# A R C H I T E C T Y P E

May 22, 2015

RE: The Science Center  
68 Maine Wharf  
Portland, Maine

4 | STAIR SECTION A  
SCALE: 1/4"=1'-0"

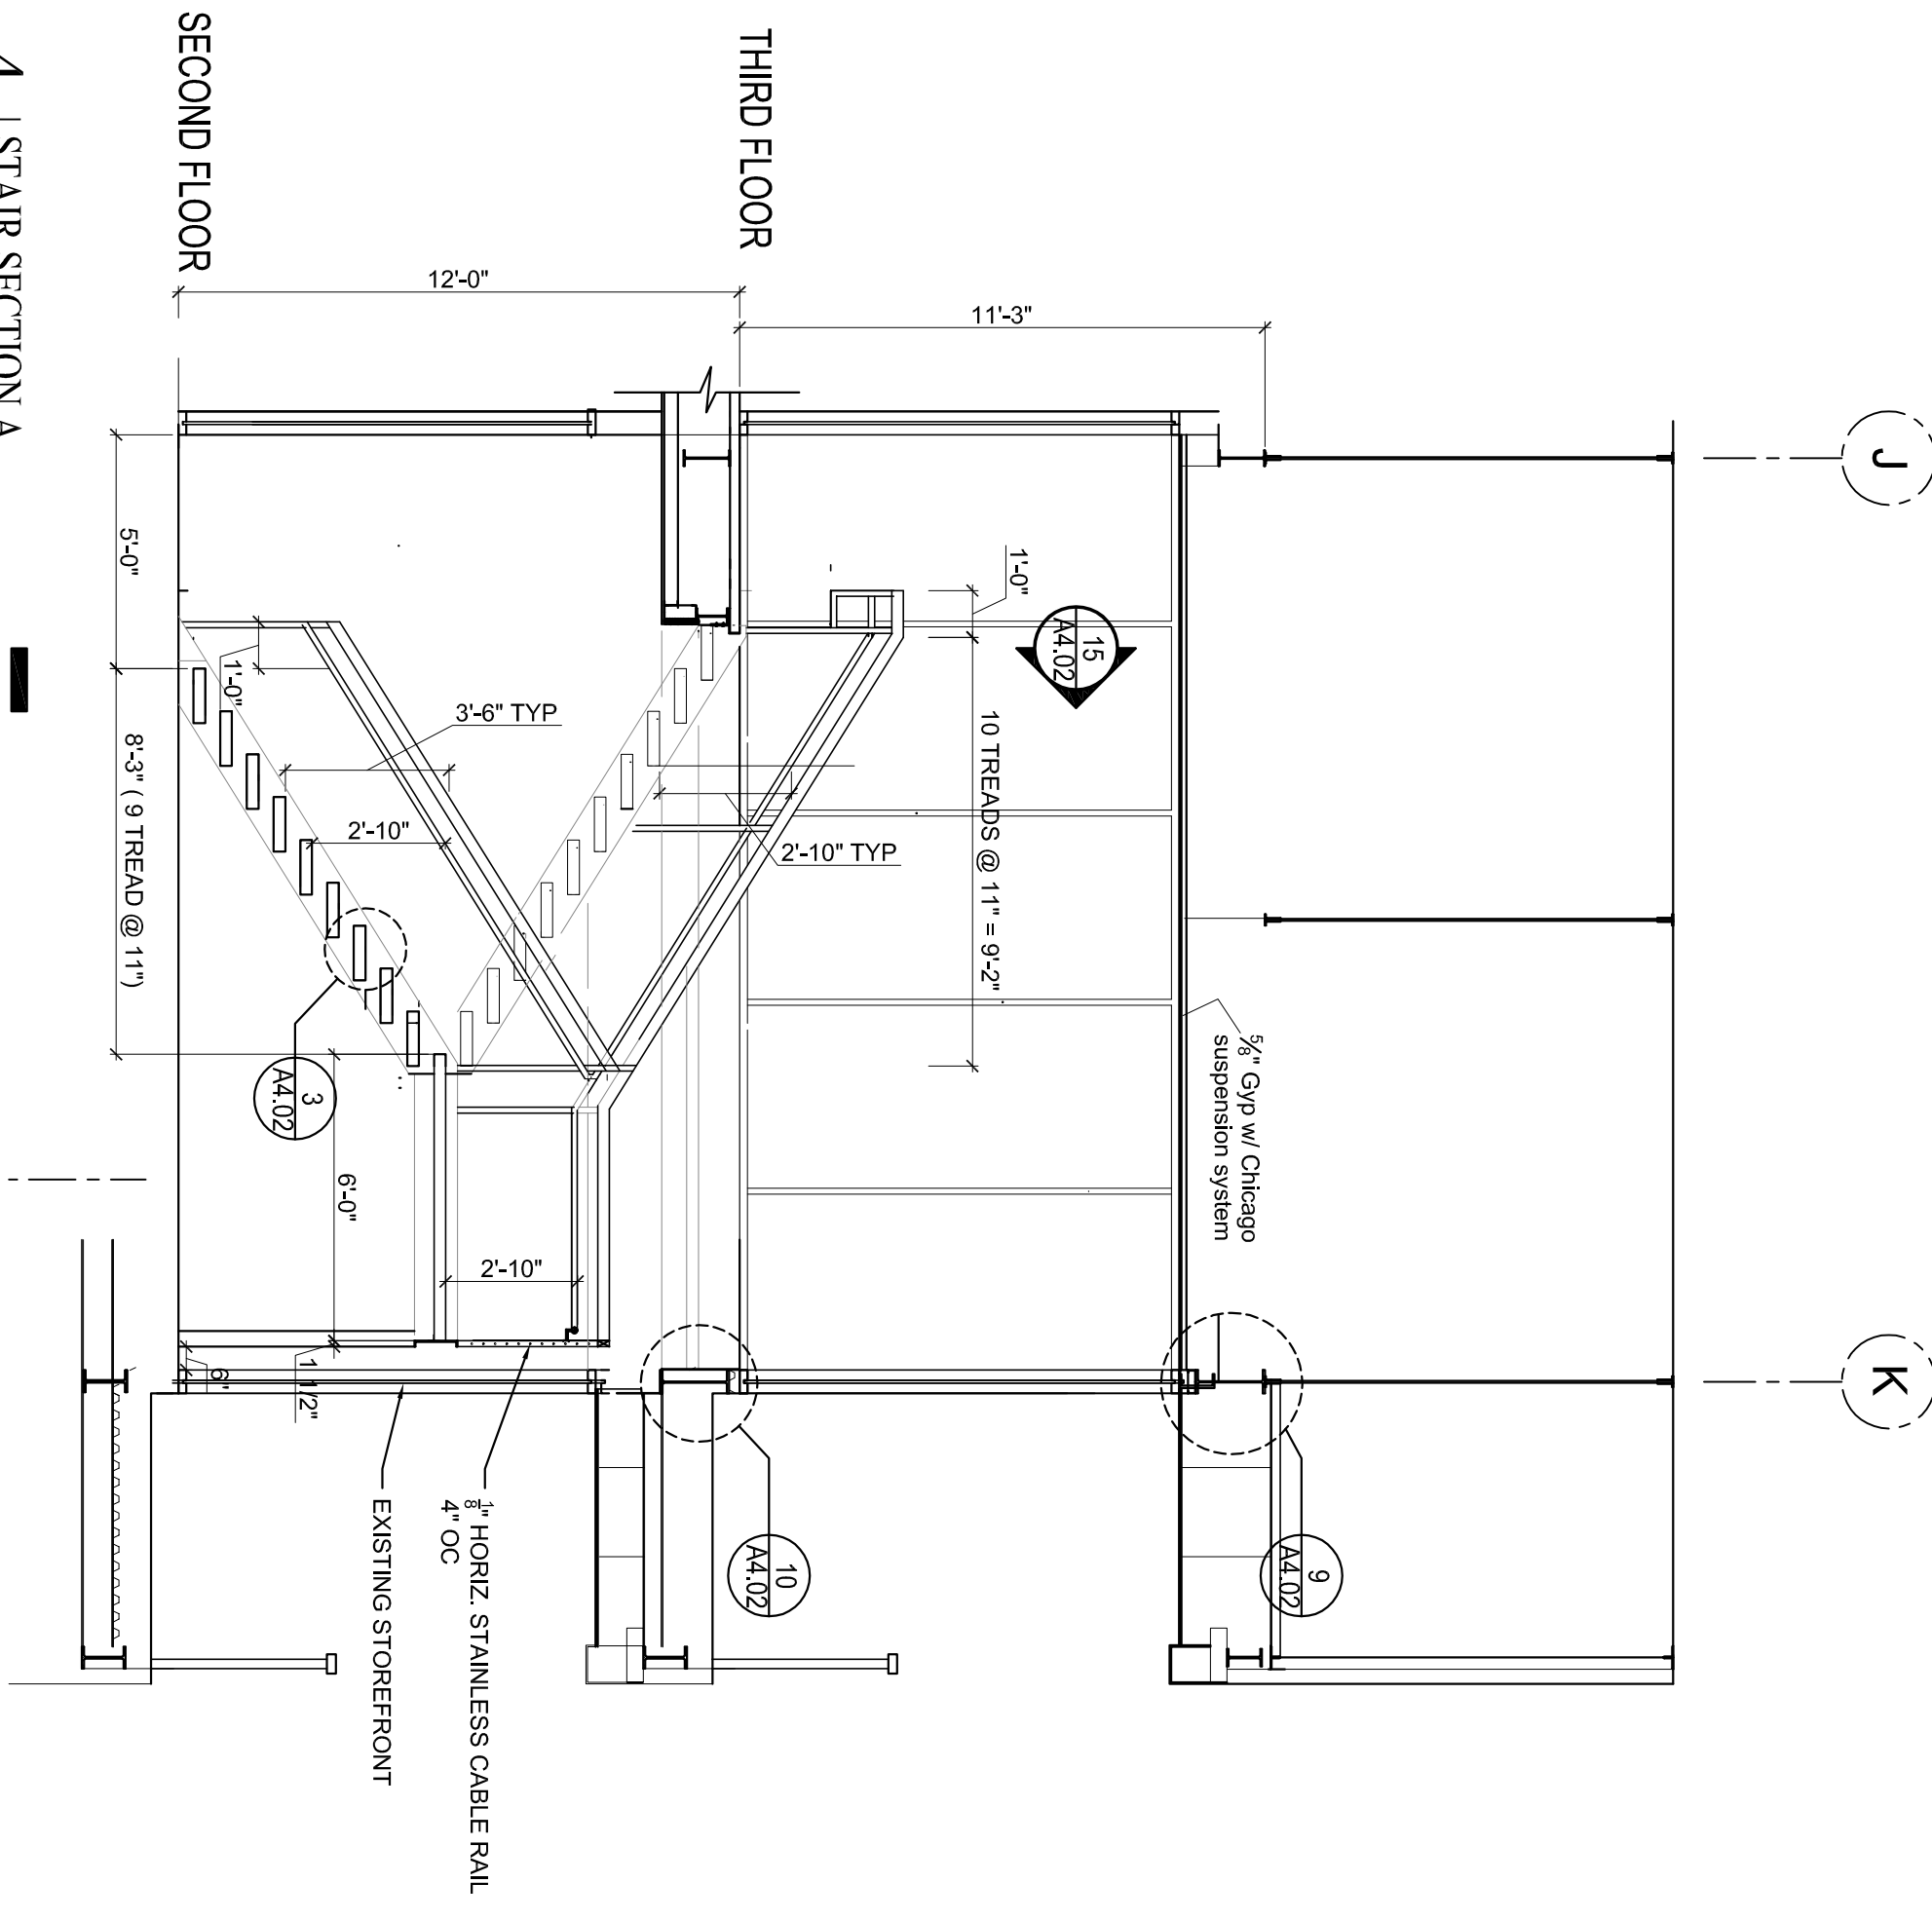
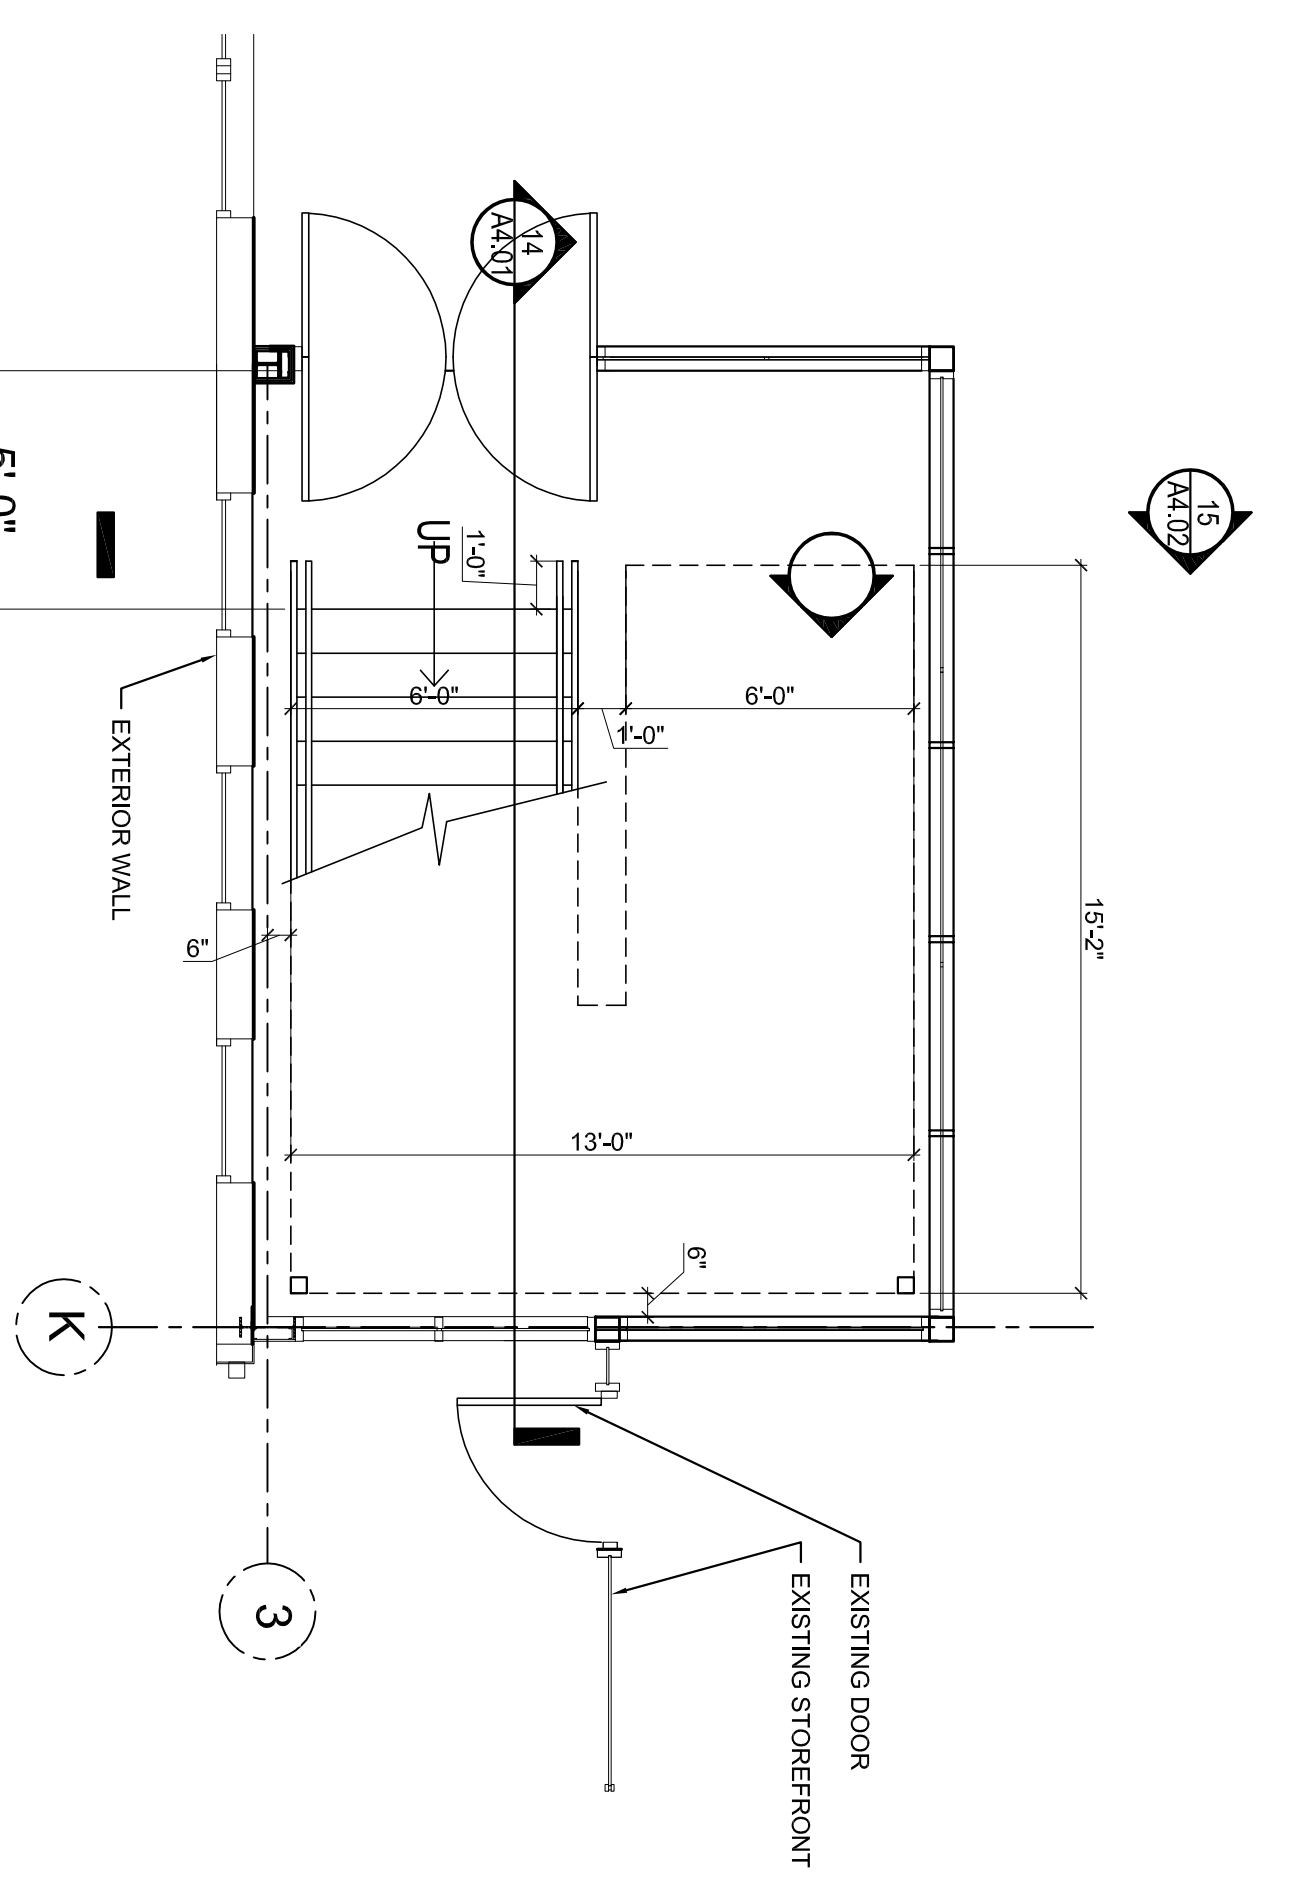
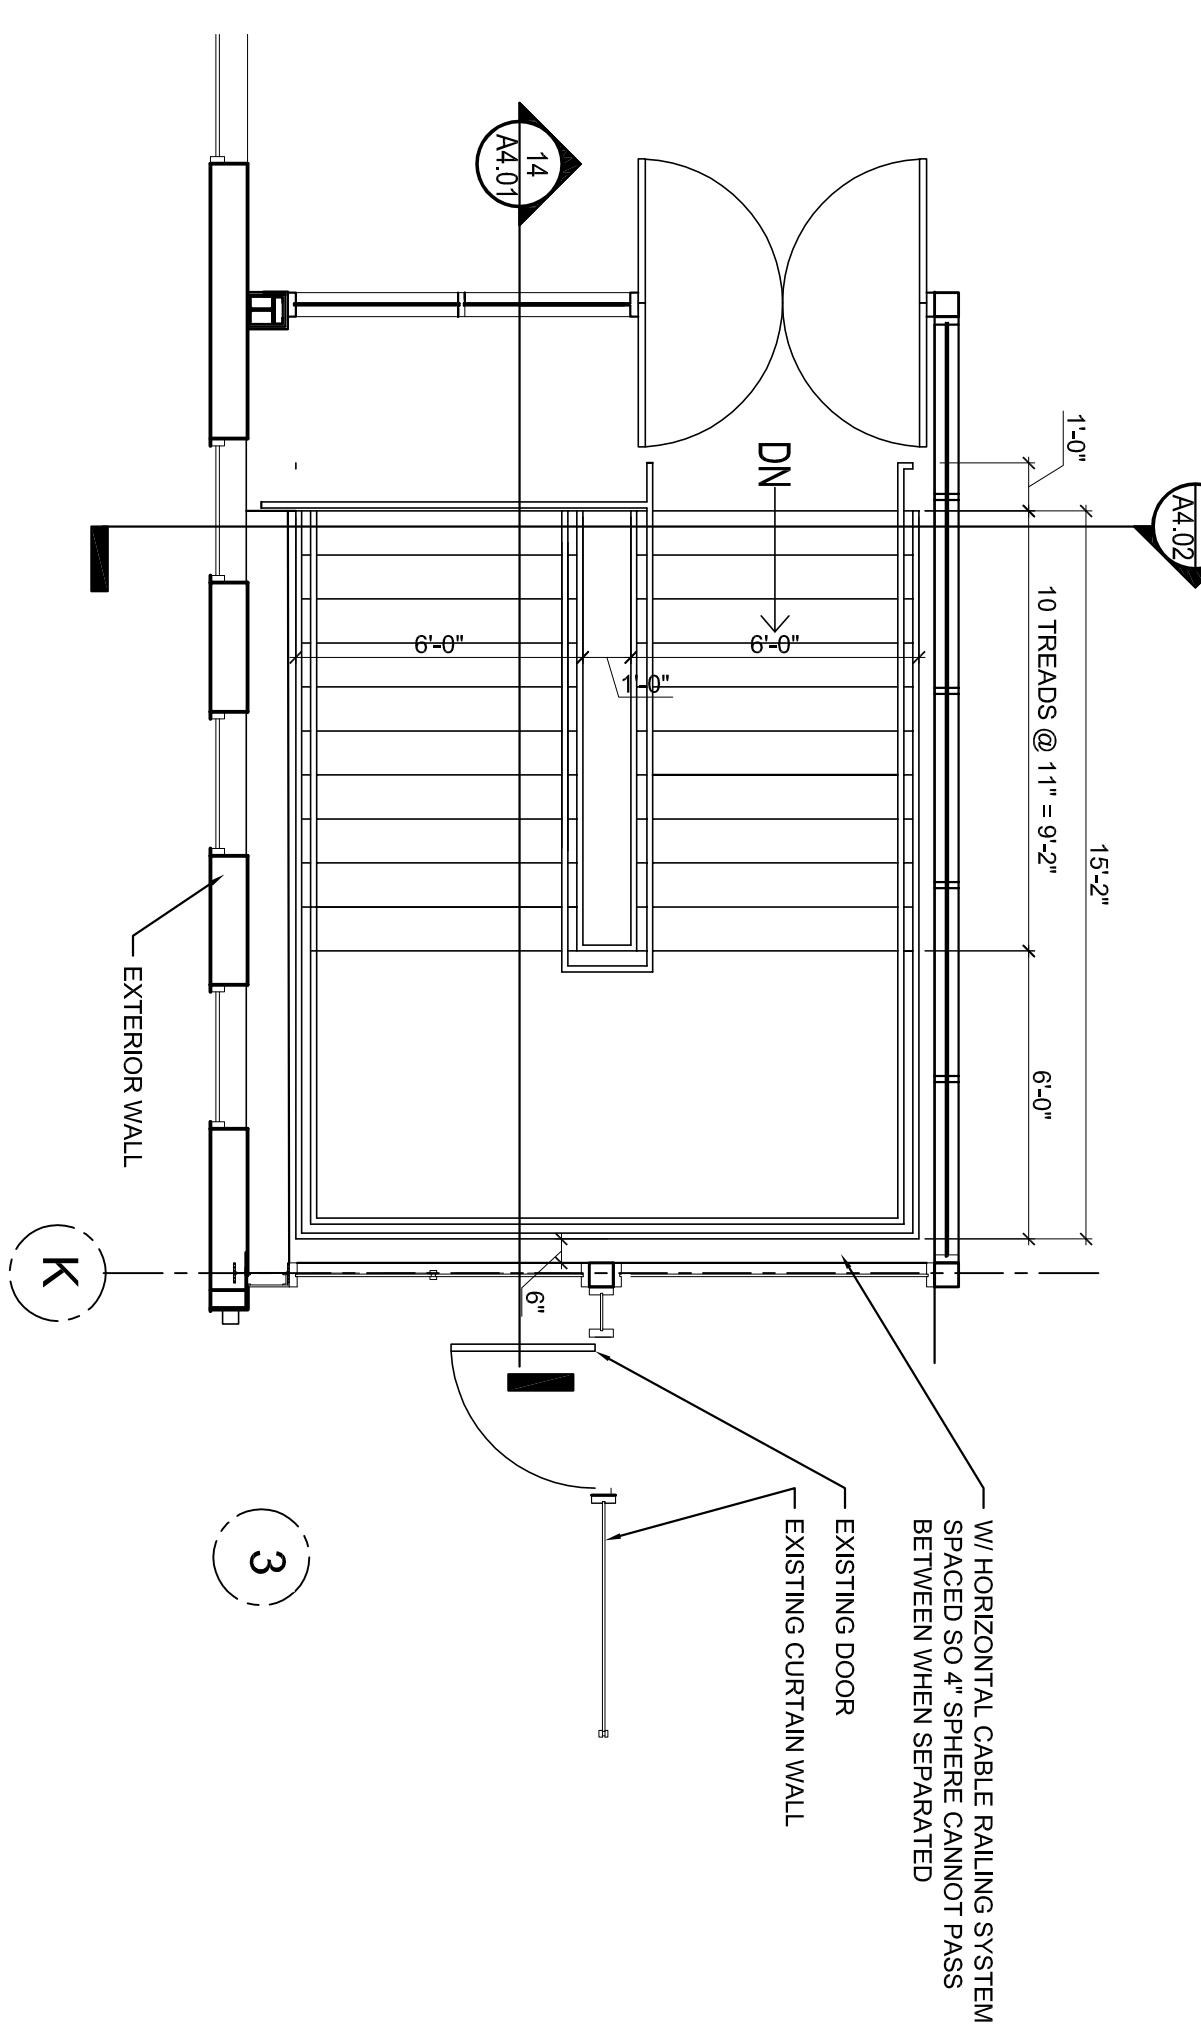
In the course of our own internal review of the project Mark Cummings of Fire Risk Management noticed that the common path of travel from the south end (or right side of the floor plan) to the nearest exit stair exceeds the allowable distance for an assembly occupancy. I have attached Marks suggestion to incorporate our proposed convenience stair into our egress along with our revised drawings.
